From: Laura Gibbons
Sent: 15 March 2019 12:14
To: Planning.Responses
Cc: Simon Davis
Subject: RE: Planning Consultation on FP/42/19/DOC

Engineers Comments Regarding Condition 7

APPLICATION **FP/42/19/DOC**

Description of Works: Approval of details reserved by condition imposed under ref
FP/171/18/PL relating to Condition Nos
5,6,7,8,9,10,11,12,13,14 & 24.

Project: Wellers Close Hampshire Homes Group	
Drawing: Soft Landscaping Concept	
Date: May 2018	Drawn by: JA
Scale: 1:200 @ A1	Revision: -

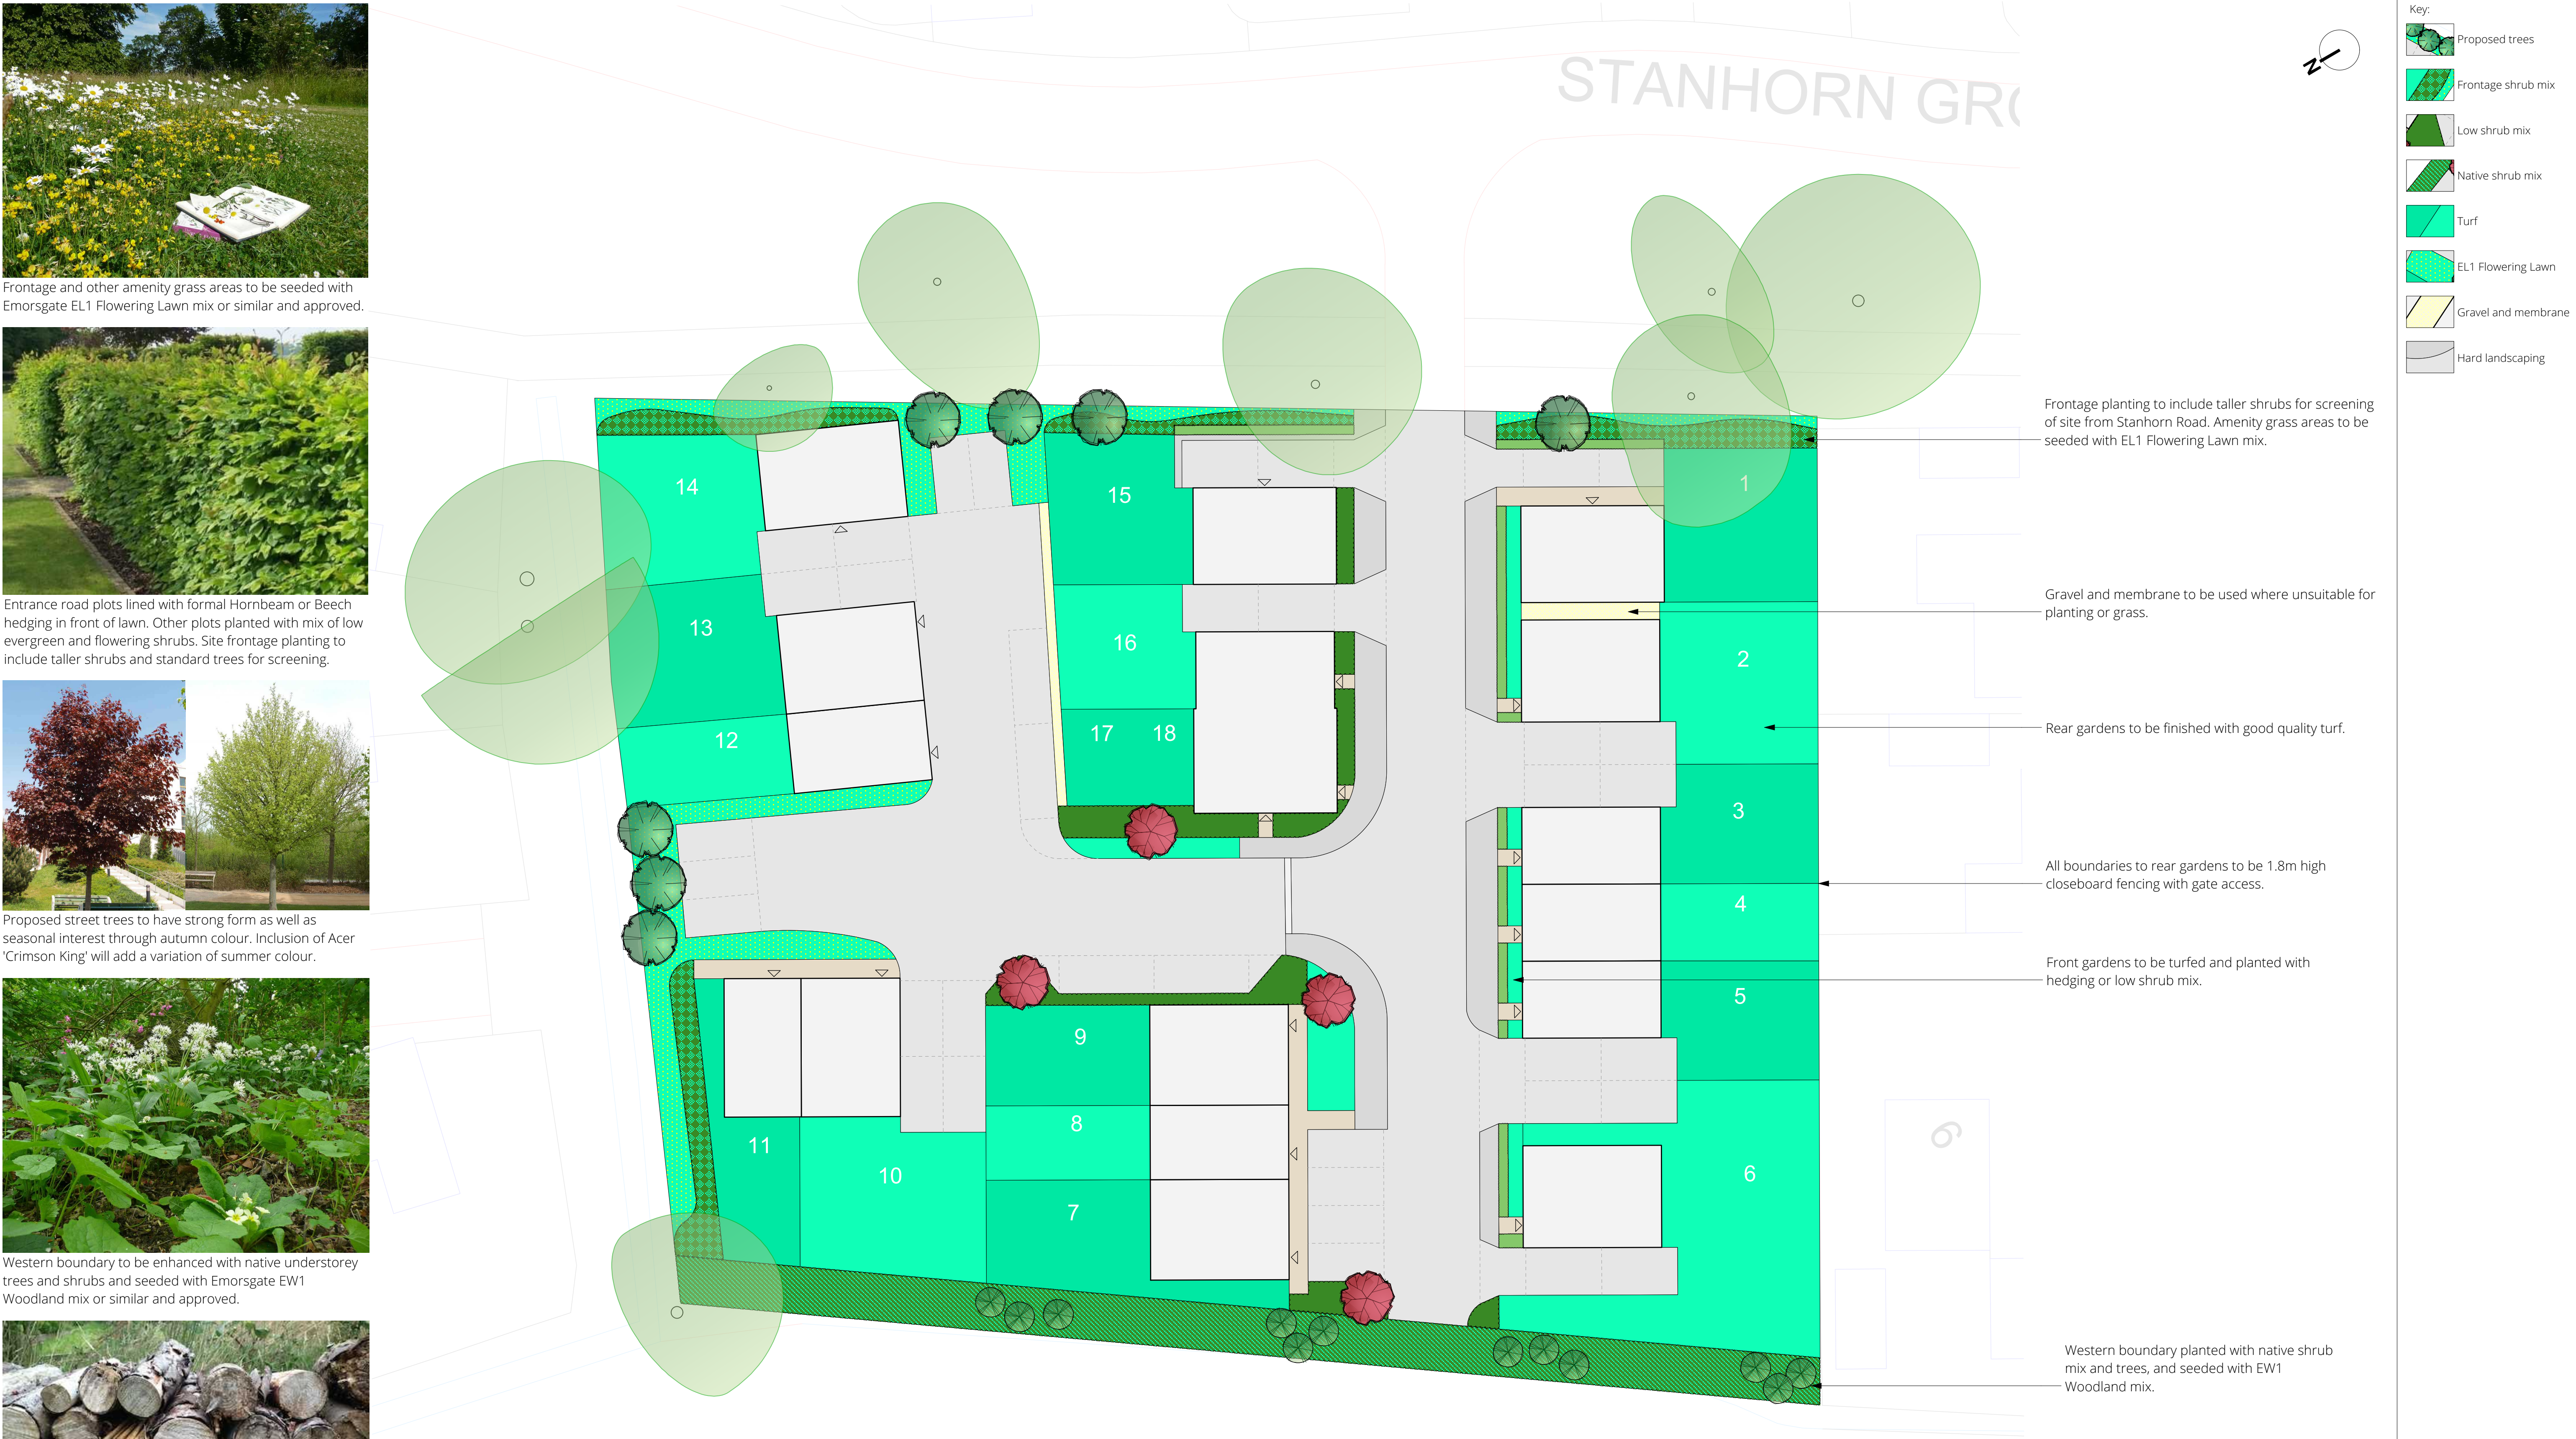
1. Catchpits must be provided upstream of all connections into the attenuation tank.
2. No construction detail drawings have been provided. Please provide construction detail drawings of manholes, catchpits, permeable paving, attenuation tank and hydrobrake.
3. There is conflict between the landscaping proposals and the drainage proposals. Trees must not be located on or near attenuation tanks. Please revise the landscaping proposals.

Rev.	Date	Note	Author	Checked
A	11/06/19	De-mountable fence indicated to rear of Plots 12 - 14	RR	JP

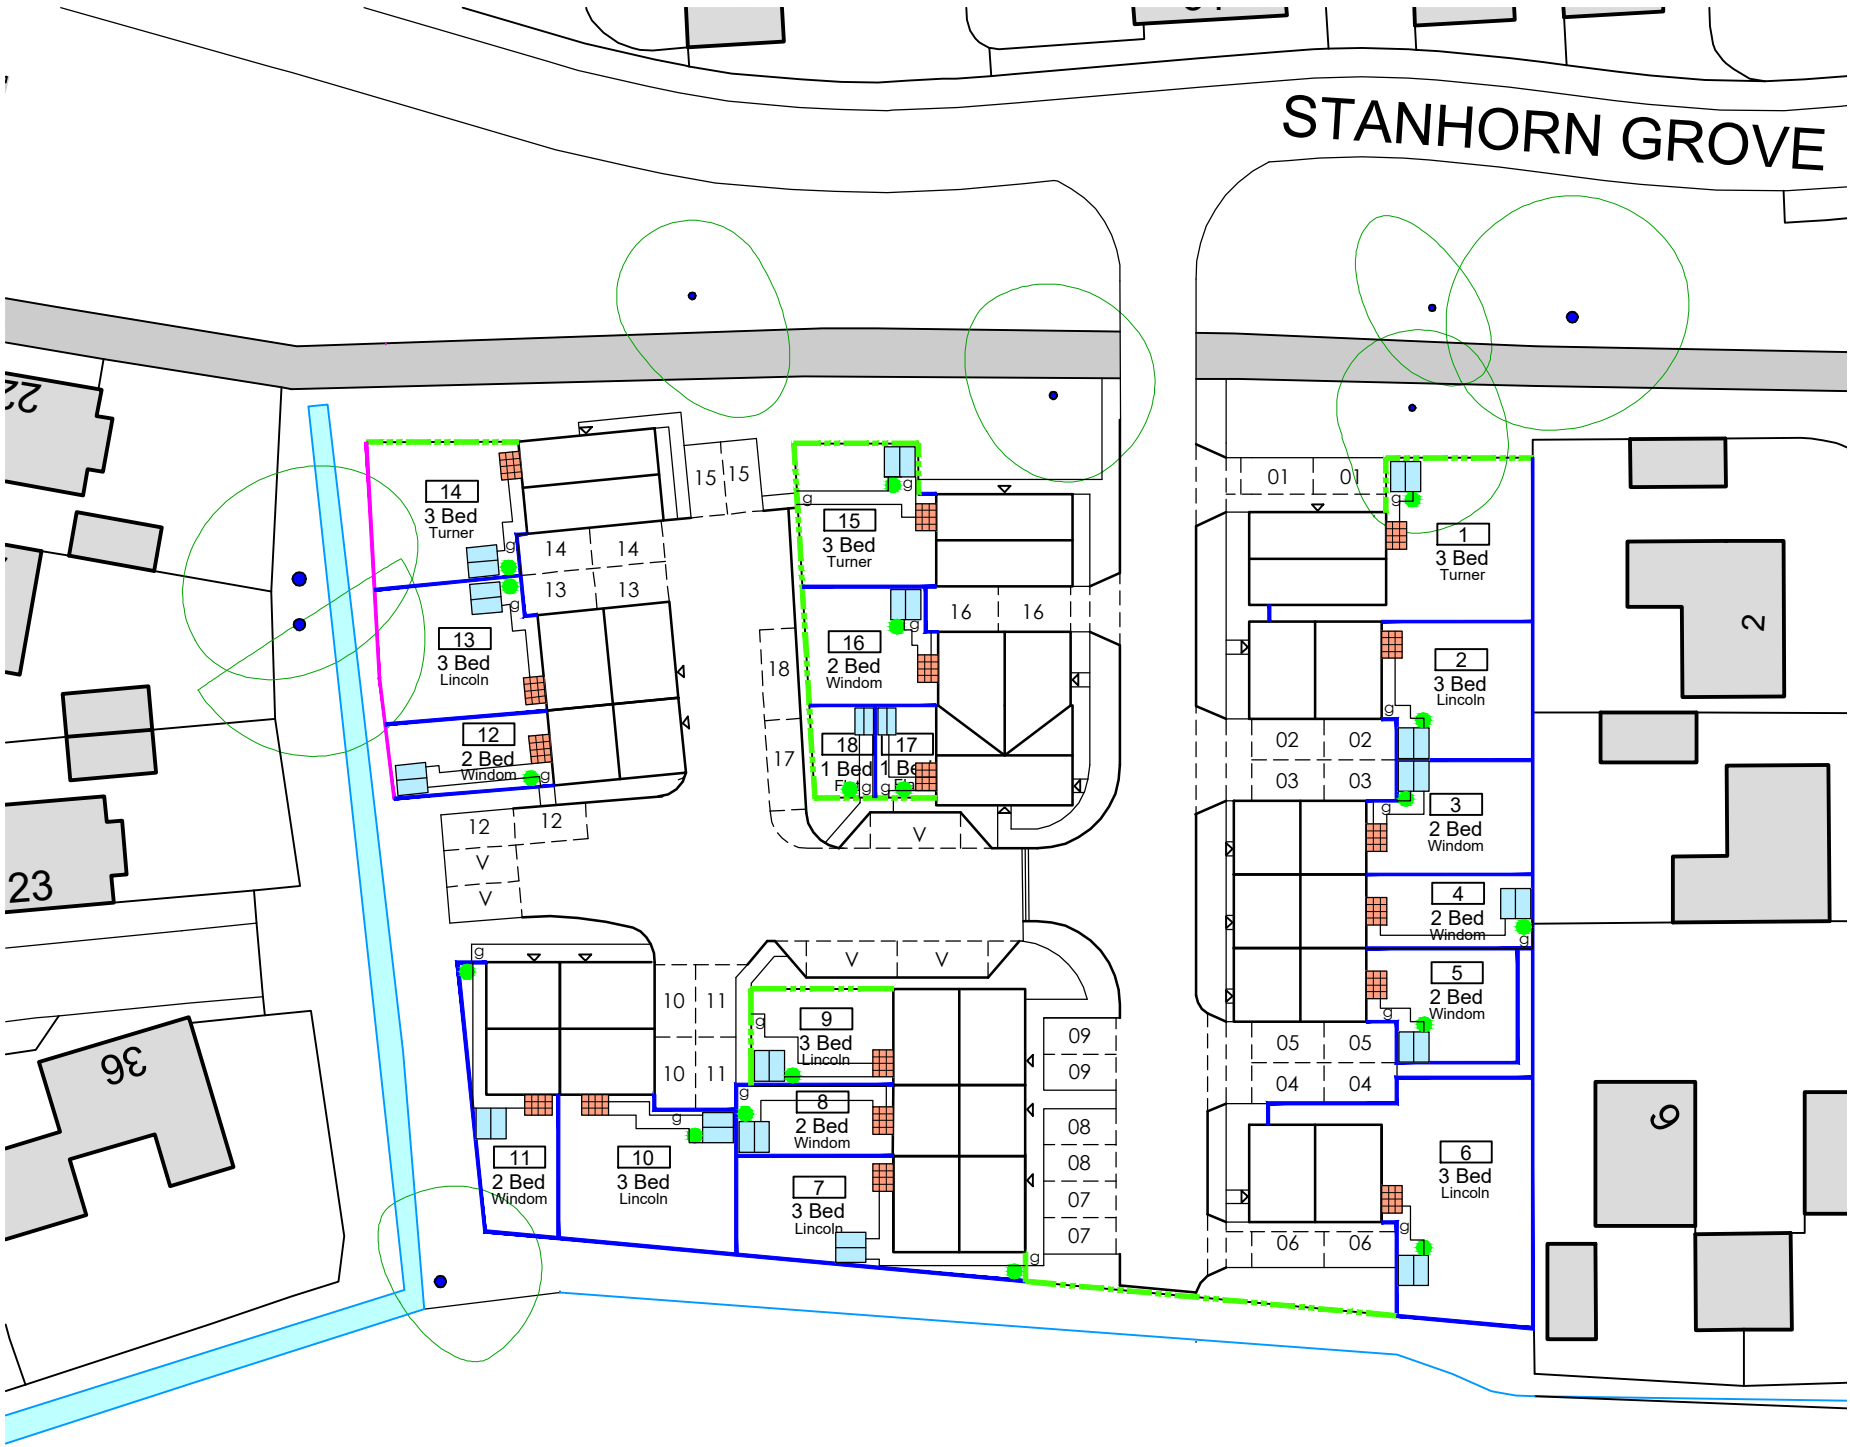
Proposed property boundaries for plots 12-14 need to be amended to allow access to the watercourse. 3m easement is required from any building, fence or wall and the top of bank of an ordinary watercourse.
